**SOIL, GEOLOGY, GEOLOGIC HAZARD,  
AND WASTEWATER STUDY  
MOUNTAINS TO VIEW ESTATES  
11150 NORTH ELLICOTT HIGHWAY  
EL PASO COUNTY, COLORADO**

April 16, 2018

Entech Job No. 180343

8

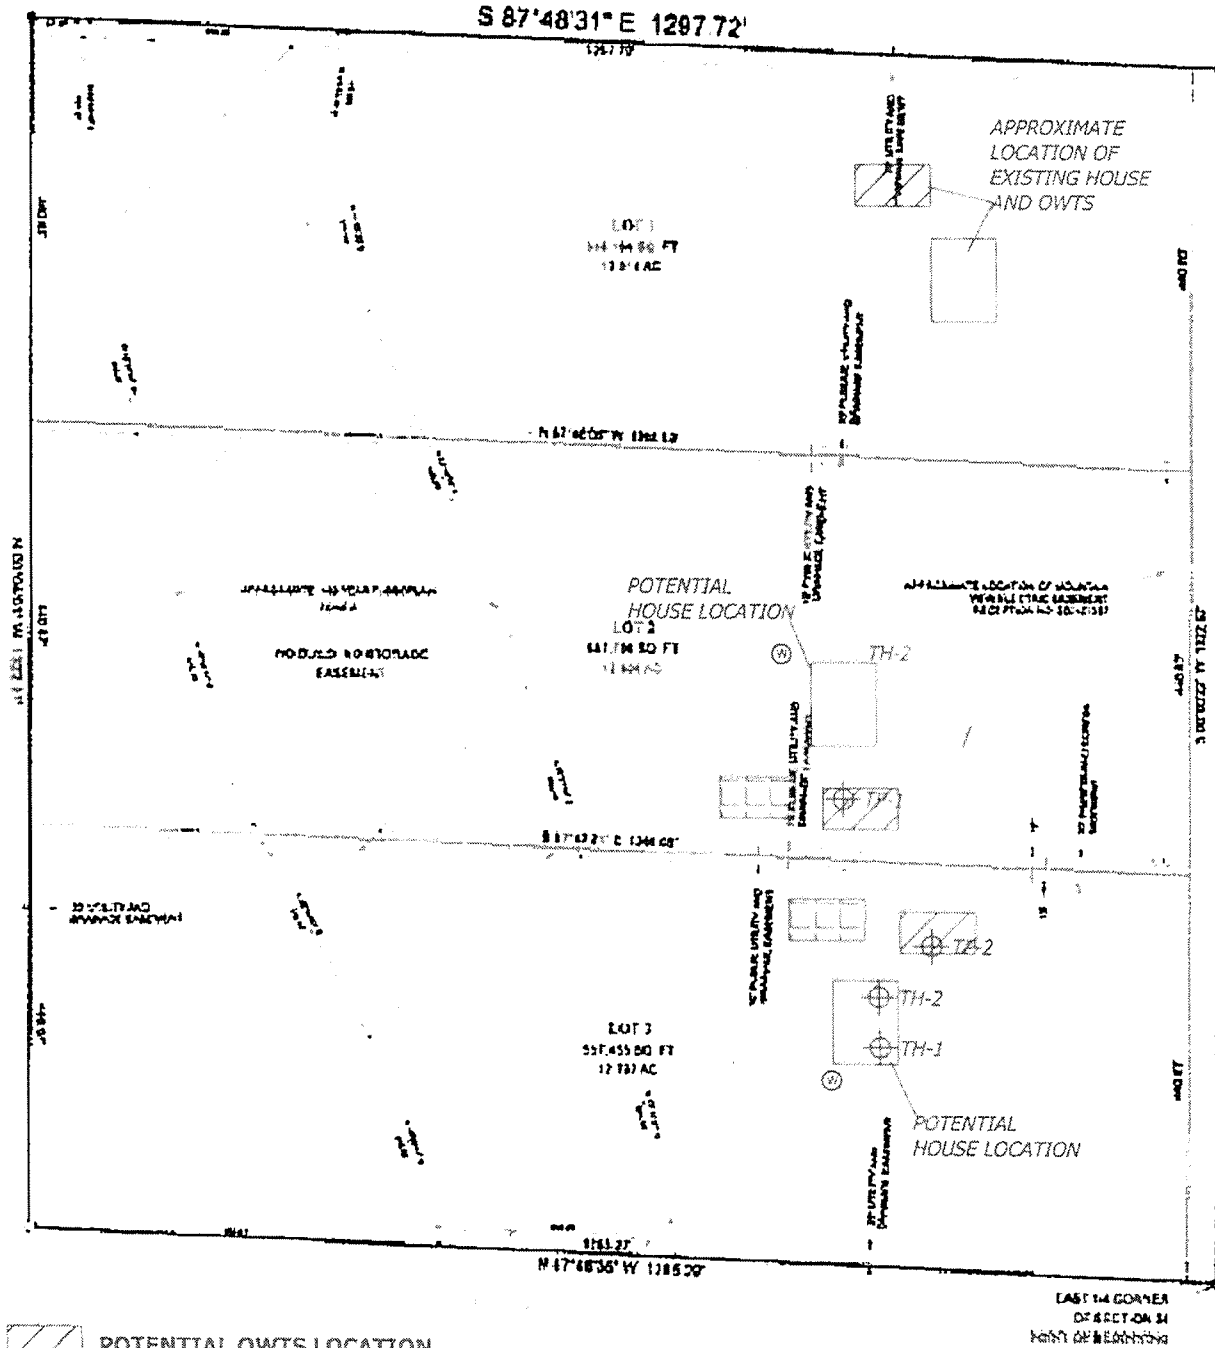
Please see MDT  
letter for Report  
requirements and  
Sections. Each site is  
required to have 2  
suitable sites for  
OWTS
